Re: Gundry Solar Farm (SSD-48225958; PAE-77853248) (Goulburn Mulwaree)– Advice on EIS

NSW Department of Primary Industries and Regional Development (DPIRD) - Fisheries is responsible for ensuring that fish stocks are conserved and that there is no net loss of key fish habitats upon which they depend. To achieve this, DPIRD Fisheries ensures that developments comply with the requirements of the *Fisheries Management Act 1994* (FM Act) (namely the aquatic habitat protection and threatened species conservation provisions in Parts 7 and 7A of the Act, respectively), and the associated *Policy and Guidelines for Fish Habitat Conservation and Management (2013)* (the Policy). DPIRD Fisheries is also responsible for ensuring the sustainable management of commercial, recreational and Aboriginal cultural fishing, aquaculture, marine parks and aquatic reserves in NSW. DPIRD Fisheries has reviewed the Response to Submissions and Amendmended documents for this proposal and provides the following advice:

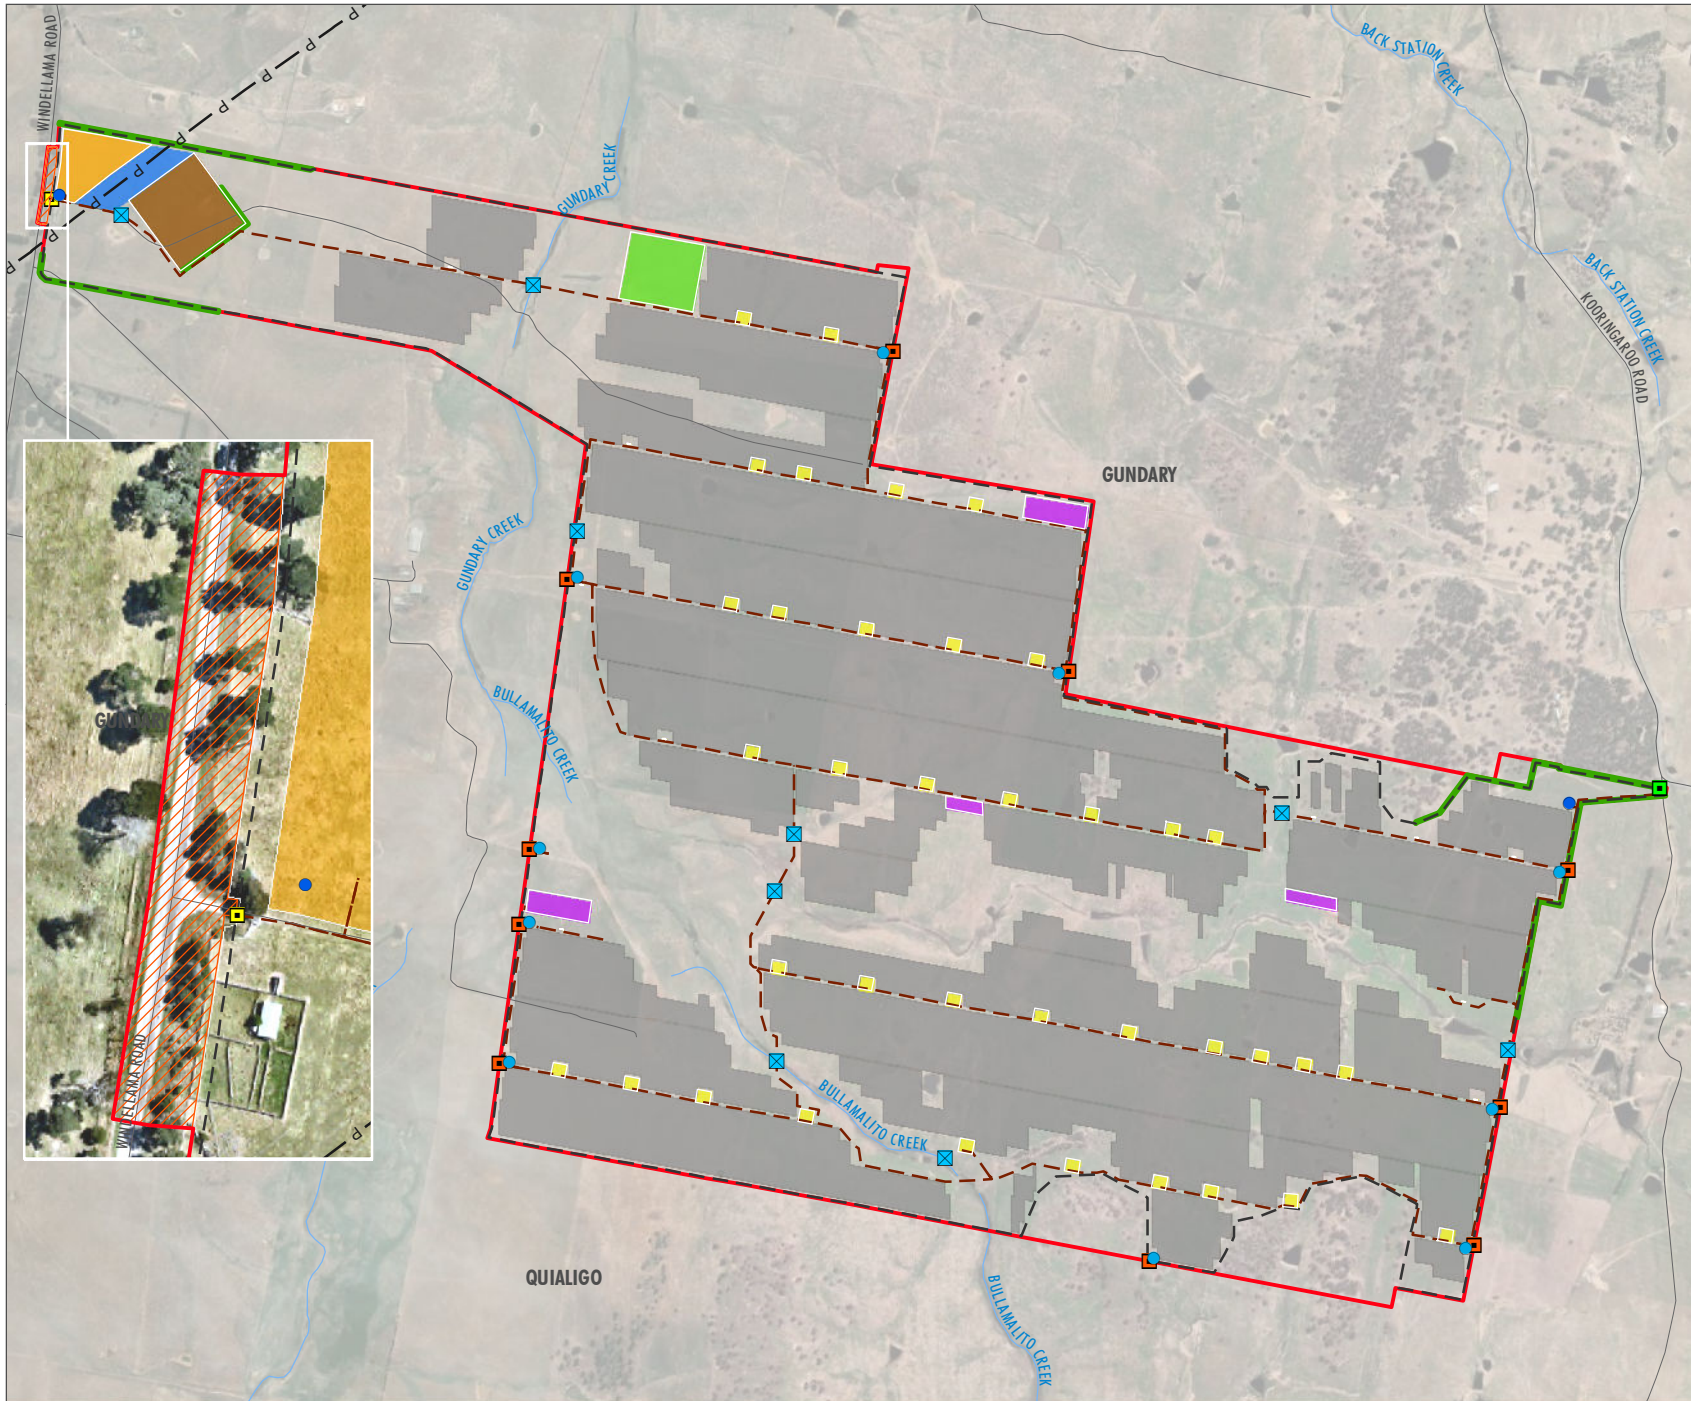
The conceptual layout shows three crossings of key fish habitat, all of which are described as Type 3 Class 3 waterways. Appendix 3 – Updated Mitigation Measures\_Final states that All waterway crossings will be designed and constructed in compliance with DPI Water Guidelines. DPIRD Fisheries request that the design and construction of all waterway crossings over key fish habitat consider the document ‘*Why do Fish Need to Cross the Road?*’ as well, to ensure no new fish passage barriers are constructed in NSW.

Crossing designs should be provided to DPIRD Fisheries for review at both the concept and detailed design phase to ensure they are consistent with the Policy.
